From: M HARVEY <[REDACTED]>
Sent: 30 September 2018 22:32
To: Amber Willard
Subject: Re: fp/190/18/t

I have received an Arboriculturalist response regarding your application at land between 3 and 9 Old Rectory Gardens, Felpham. Unfortunately the tree officer was unable to identify the tree you specified as a Bay tree and therefore is unable to determine that element of the application.

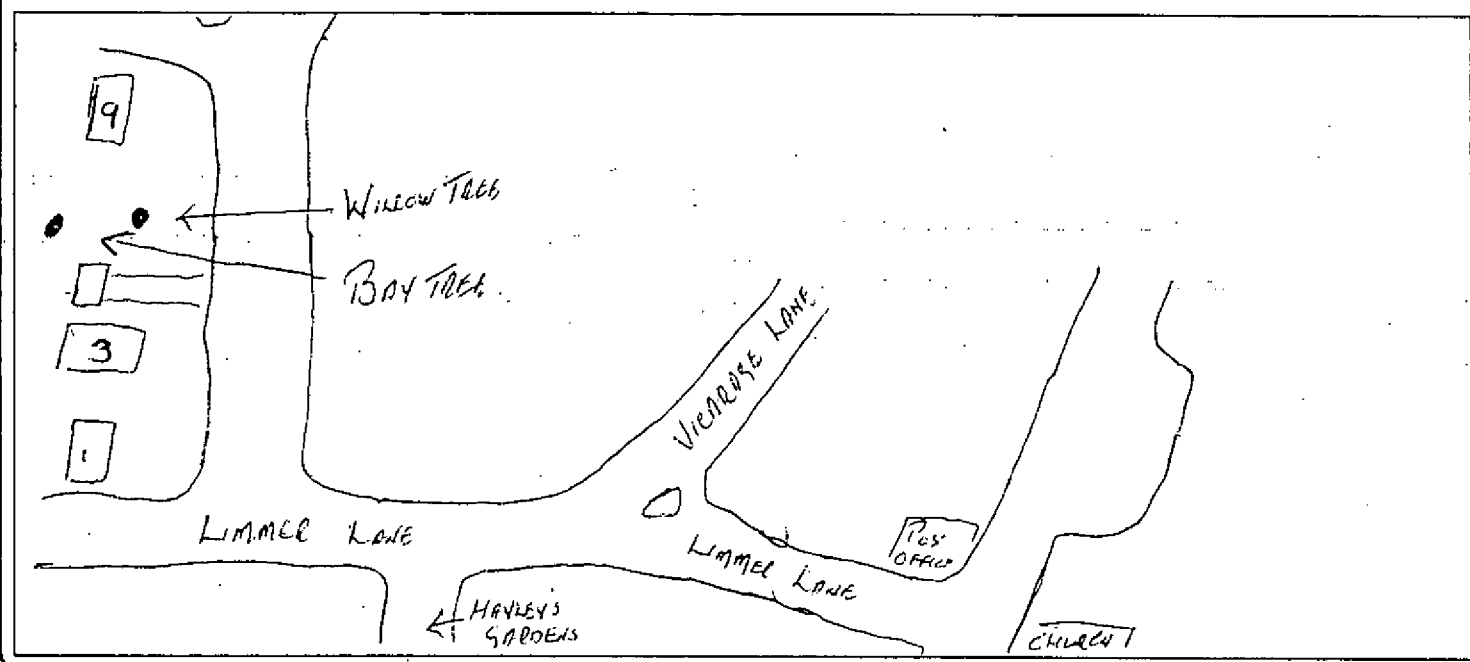
The willow tree is correctly identified and plotted reasonably accurately on the plan. I am able to make a determination on this element of the application although I would advise the applicant subsequently considers stating an intention to remove low growth above the adjacent road to a minimum height of 5metres and back to the kerbline, in a new application. On completion, that work would meet their obligation to ensure unobstructed access along the public highway for high-sided vehicles.

The only bay tree (*Laurus nobilis*) in the immediate locality is a small specimen of no more than 5metres height, growing approximately 8metres due southeast of the aforementioned willow and adjacent a boundary fence. It grows from within the rear garden of 24 Limmer Lane. This is a considerable distance from the position marked on the applicant's plan. The mark would seem to correspond with the position of a mature silver birch tree.

The information provided in relation to the bay tree does not correspond with my observations on site, so I am unable to determine this element of the application.

I suggest the applicant re-submits an application following advice from a Tree Specialist who will be able to correctly identify and accurately plot on a map all trees intended for work. This must be supported by an appropriate and comprehensive work specification, to enable us to make an informed decision.

Following his comments, I am unable to recommend a decision on the Bay tree, I am however able to amend the description of the application to remove the proposed works to the Bay tree. This would allow no objection for the works to the Willow Tree.
